REQUEST

Current Zoning: NS HDO (neighborhood services, historic district overlay)
Proposed Zoning: NC(EX) HDO (neighborhood center, exception, historic district overlay)

Approximately 0.517 acres located at the southeast intersection of Cleveland Avenue and East Worthington Avenue, south of East Boulevard.

The petition proposes to allow neighborhood center uses in the existing building on the site in addition to the relocation of the historic Leeper & Wyatt building to the portion of the site that is currently utilized as surface parking.

**RZ1.0**

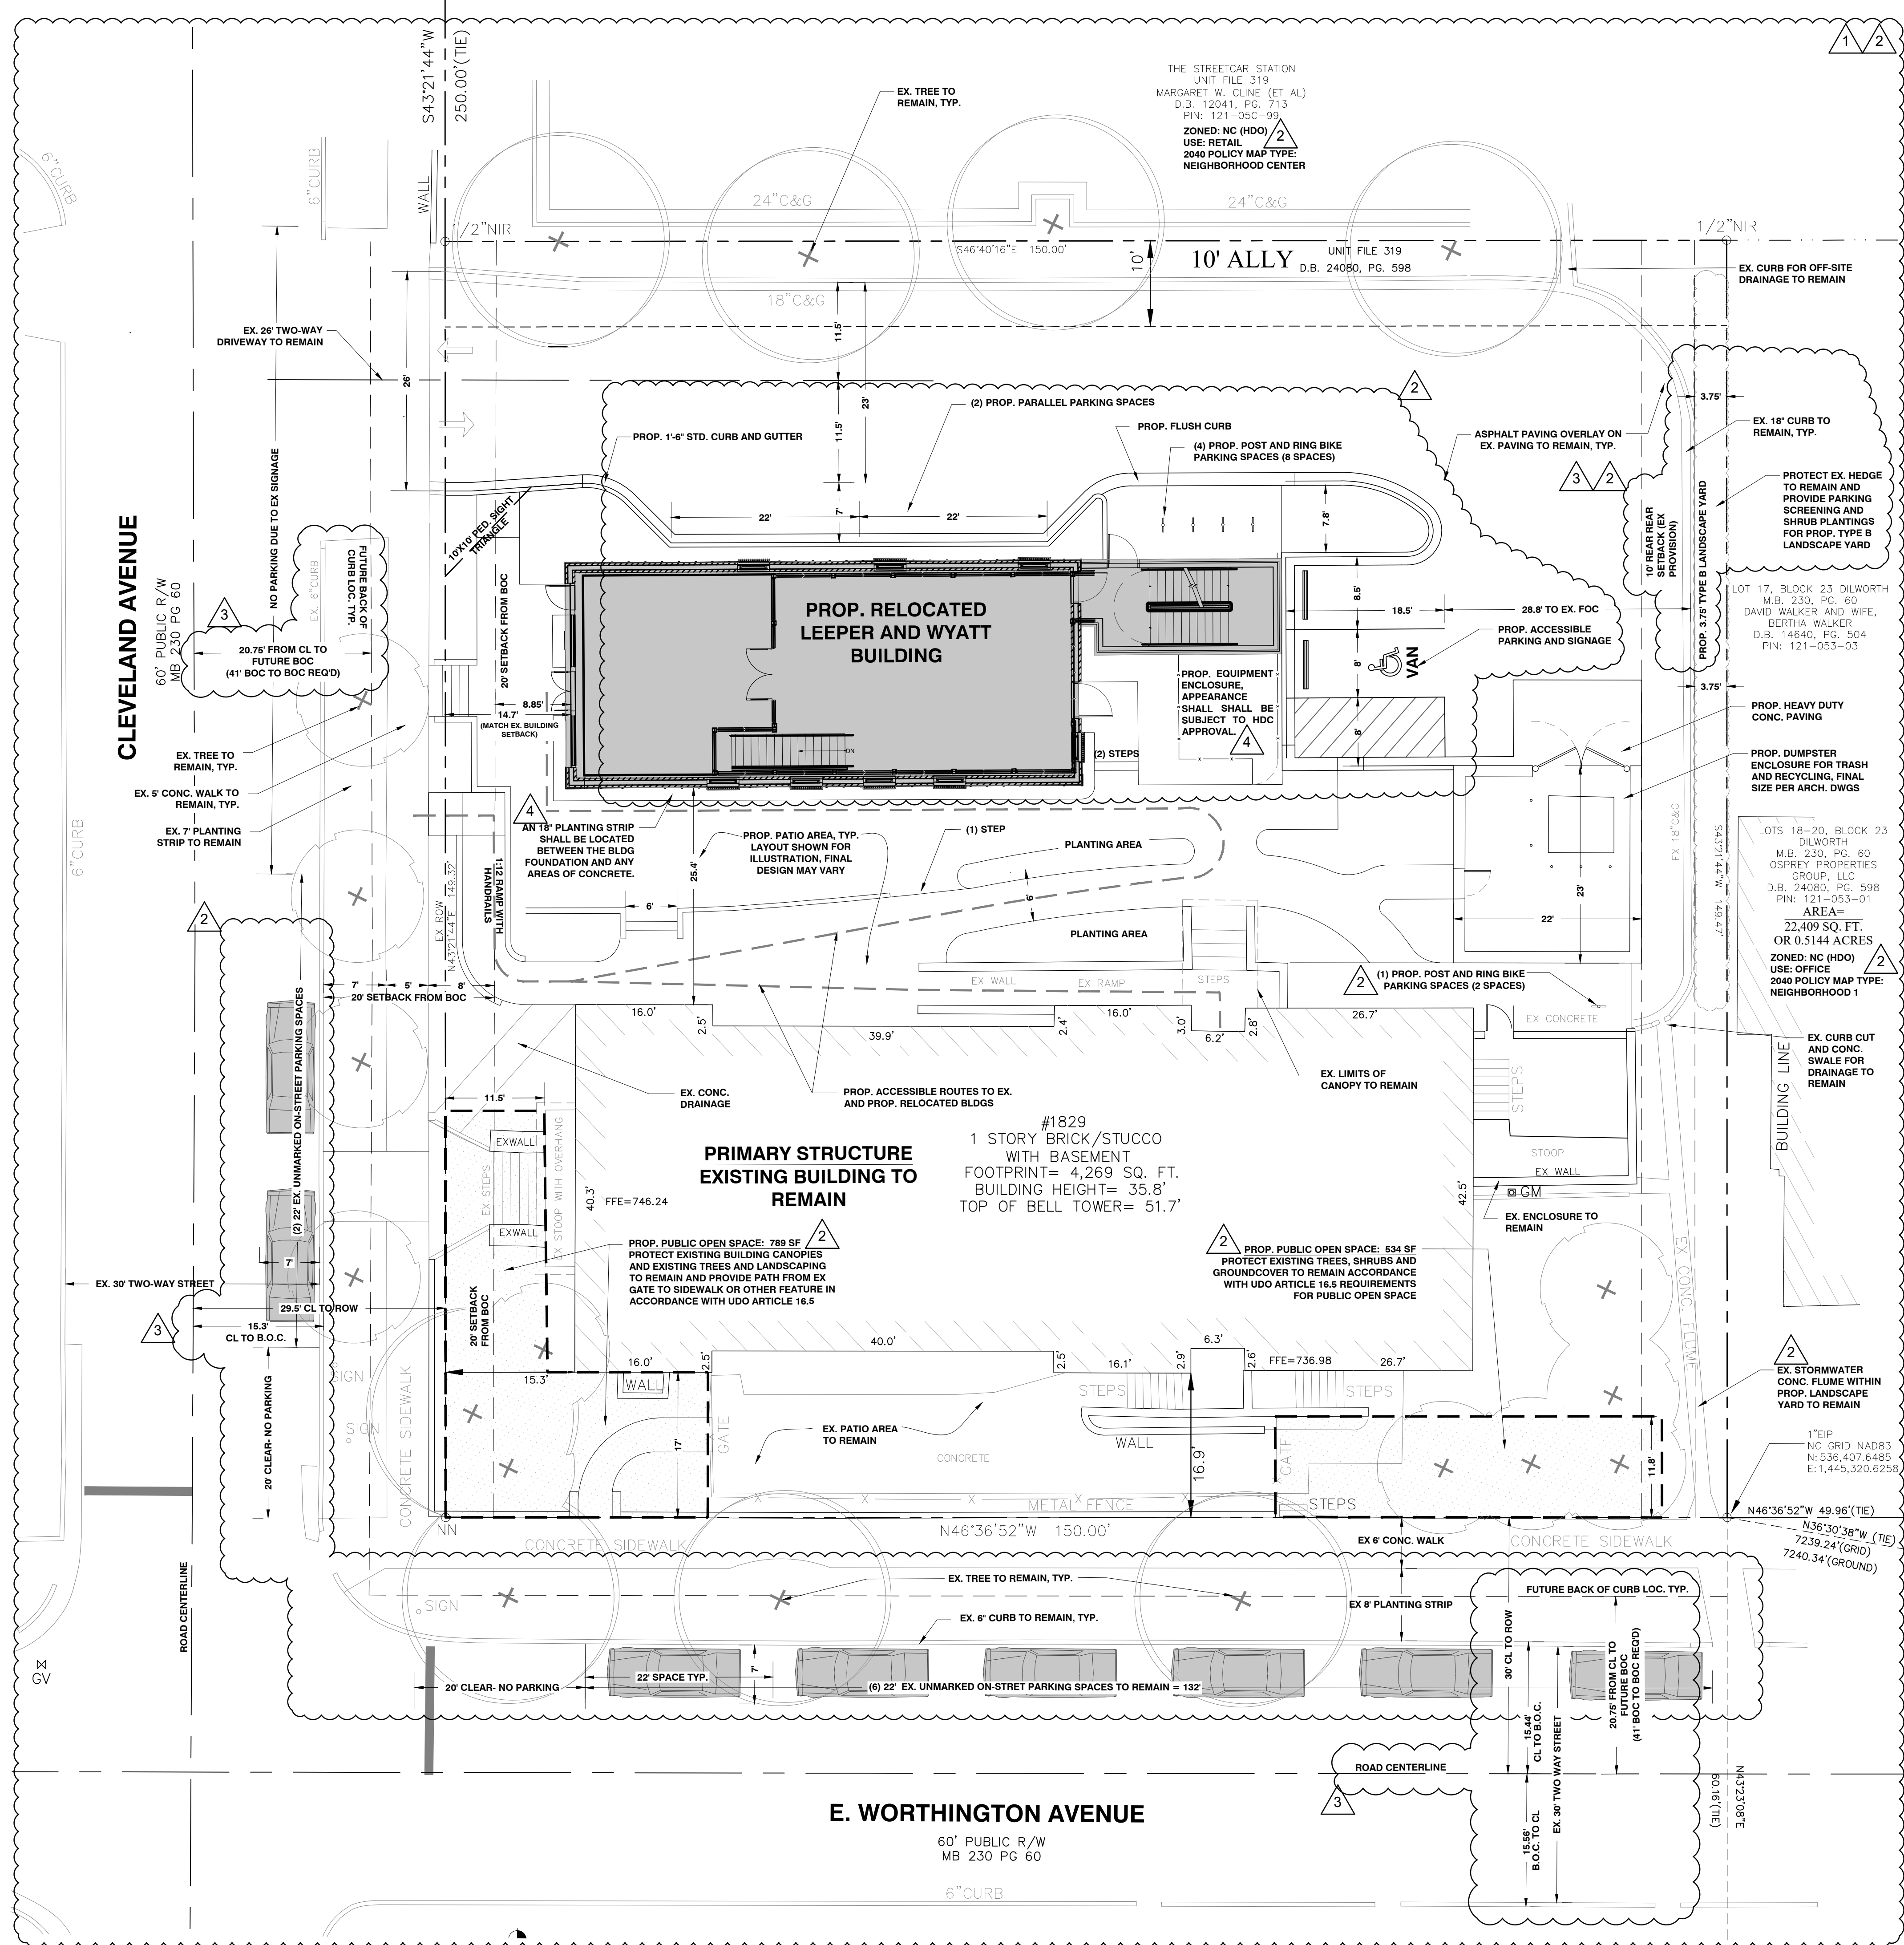
- 1.—~~Cleveland Avenue and Worthington Avenue are both shown as 30’ wide streets on current site plans. These streets must be at least 41’ wide from back of curb to back of curb per CLDM U-05. Additionally, each road must label and dimension future back of curb location to the centerline.~~
Addressed

- 5.—~~Revise the site plan to show the centerline on each public street. Dimension the right-of-way and the back of curb from the centerline.~~**Addressed**

- 6.—~~Update labeling on the site plan to list the setback against the N1 parcel as the rear setback rather than side setback.~~**Addressed**
- 7.—~~Update the wording in the parking summary table to clearly distinguish between ordinance requirements, and the various types of parking being provided. The ordinance requires 22 off-street spaces for restaurant/bar uses, what is being provided through the EX provision is 4 off-street spaces. Separately from that, the proposal includes 8 on-street spaces and 10 off-site leased spaces. Rather than listing out the parking as being in the two categories of on-site and off-site, it should be listed as off-street, on-street, and off-site leased spaces.~~**Addressed**
